From: planning
Subject: FW: app3/2017/0161 Stoneyhurst new access road

From: Bloomer, David [<mailto:David.Bloomer@lancashire.gov.uk>]
Sent: 13 March 2017 13:20
To: Adrian Dowd
Cc: LHS Customer Service; planning
Subject: app3/2017/0161 Stoneyhurst new access road

Stonyhurst College
Proposed Access Plan & Long Section

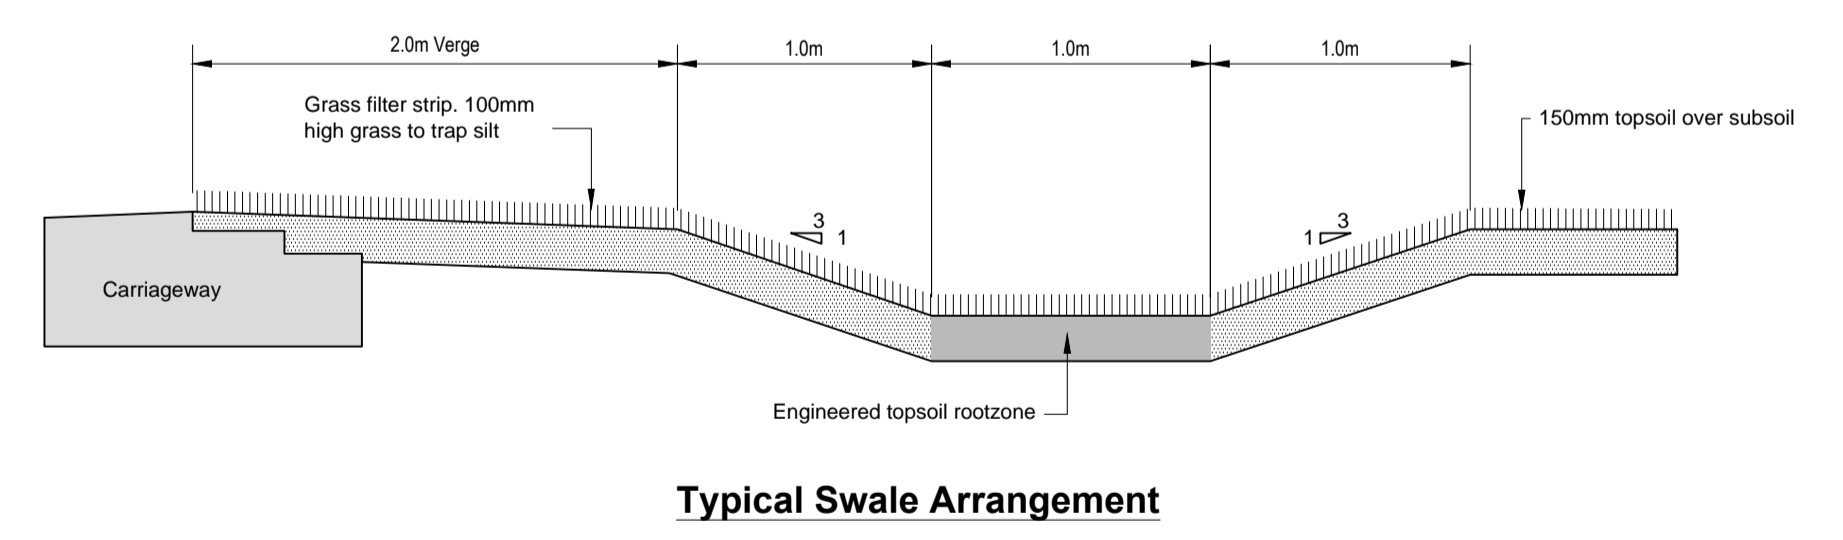
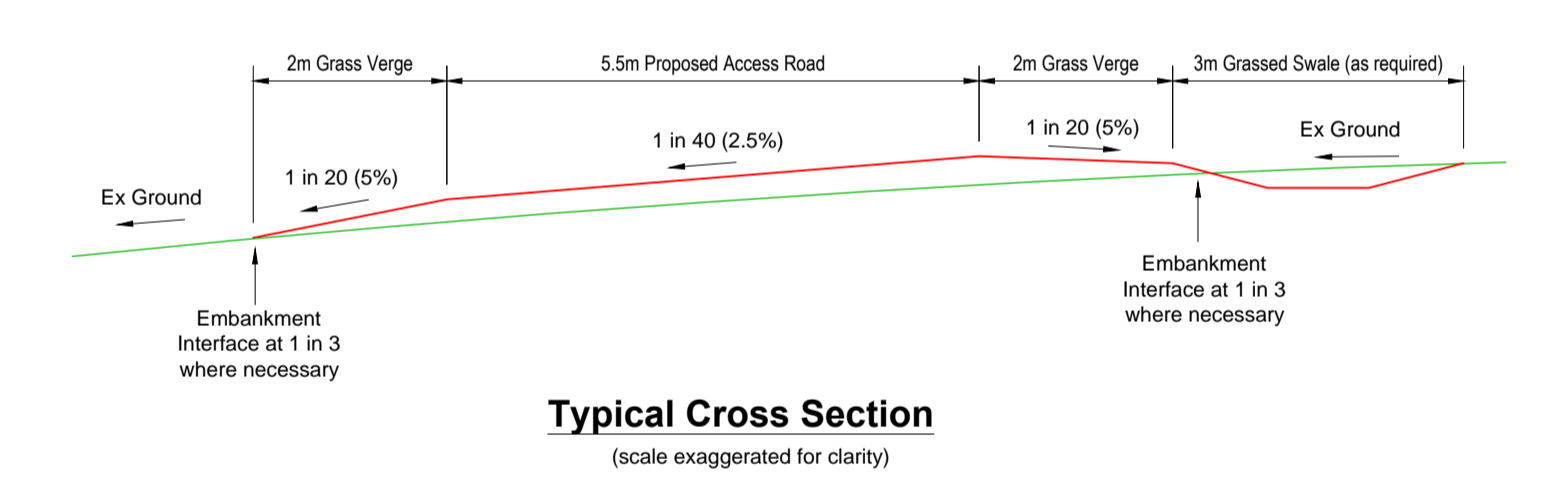
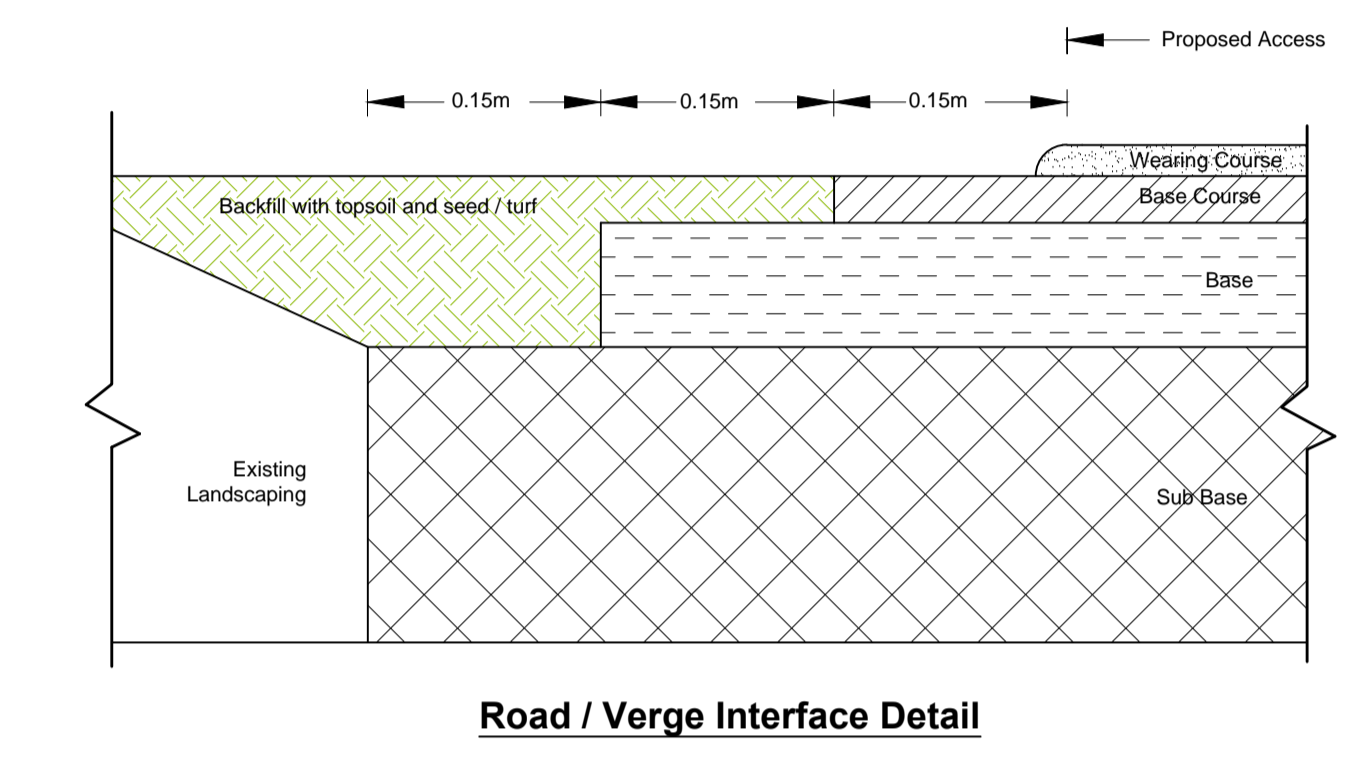
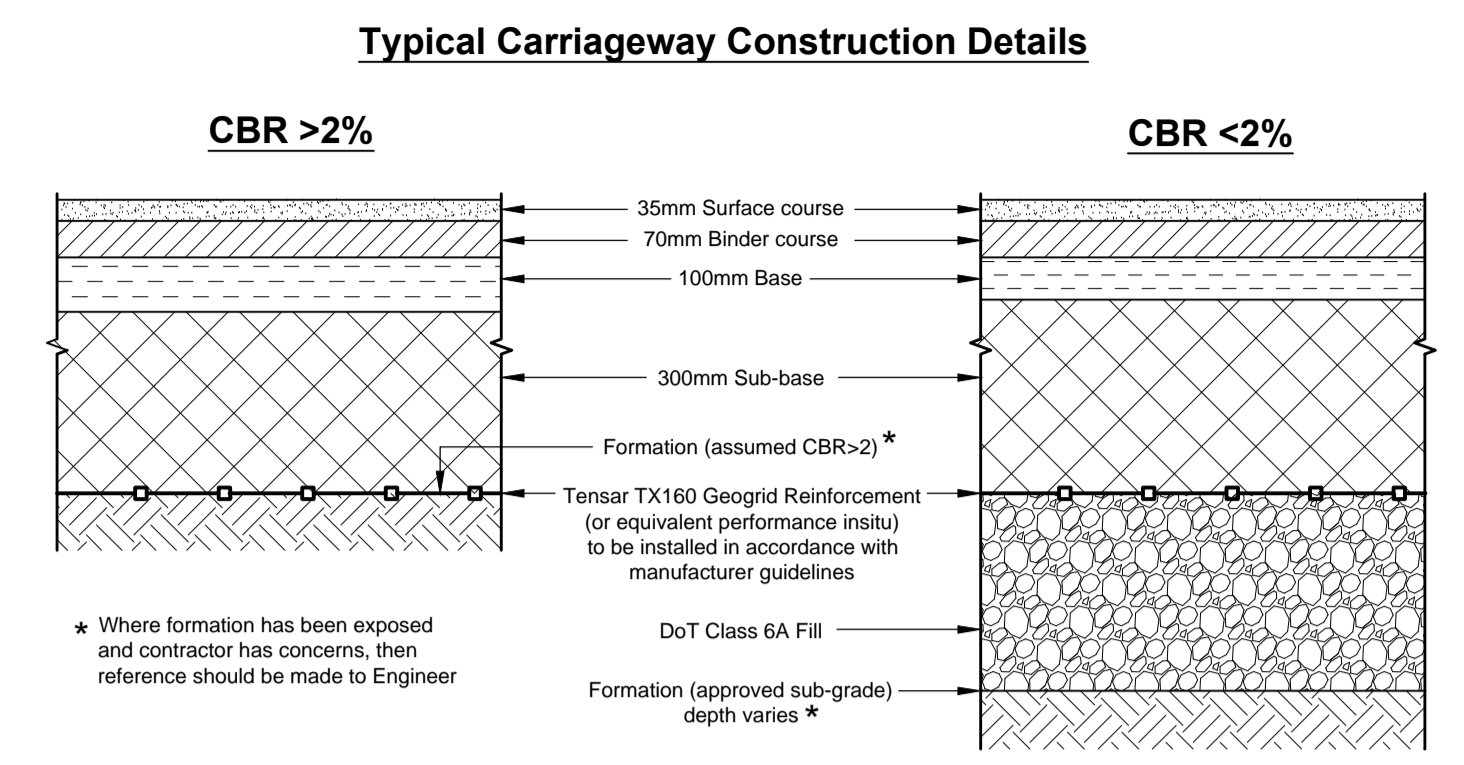
1 During the previous discussions , the applicant proposed the construction of a layby adjacent to the carriageway to the north of the college entrance. This is shown in at least 1 of the submitted plans (proposed access and long section) but it is not mentioned in the application description. I would need confirmation whether or not this forms part of the application proposals.

2 The applicant would need to provide details of the signing and lining that is to be provided at the site entrance
